Application No: LY/9/20/HH
Site Address: The Granary Calceto Lane Lyminster BN17 7QL
Description of works: Conversion of existing garage to ancillary accommodation to the principal dwelling.

Thank you for your internet representation made on 13th August 2020 which has been recorded as support with the comments as follows:

PP0520/14

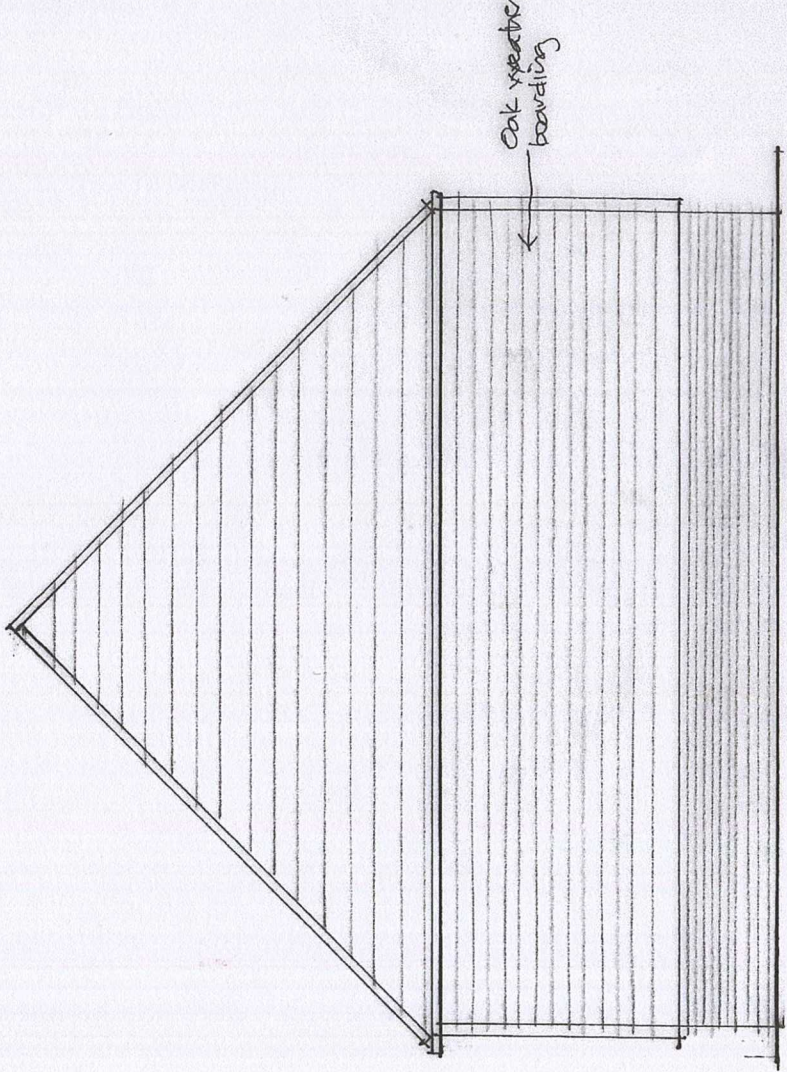
On reflection, the parish council have decided that they will support this application, but would like to add a proviso. As it stands the velux windows open to the west directly overlooking the neighbouring two houses. If the windows could open to the south or east, they would only overlook the garden of the owners of this property, and therefore would pose no intrusion on neighbouring properties. Please take this into consideration when making your decision. Many thanks
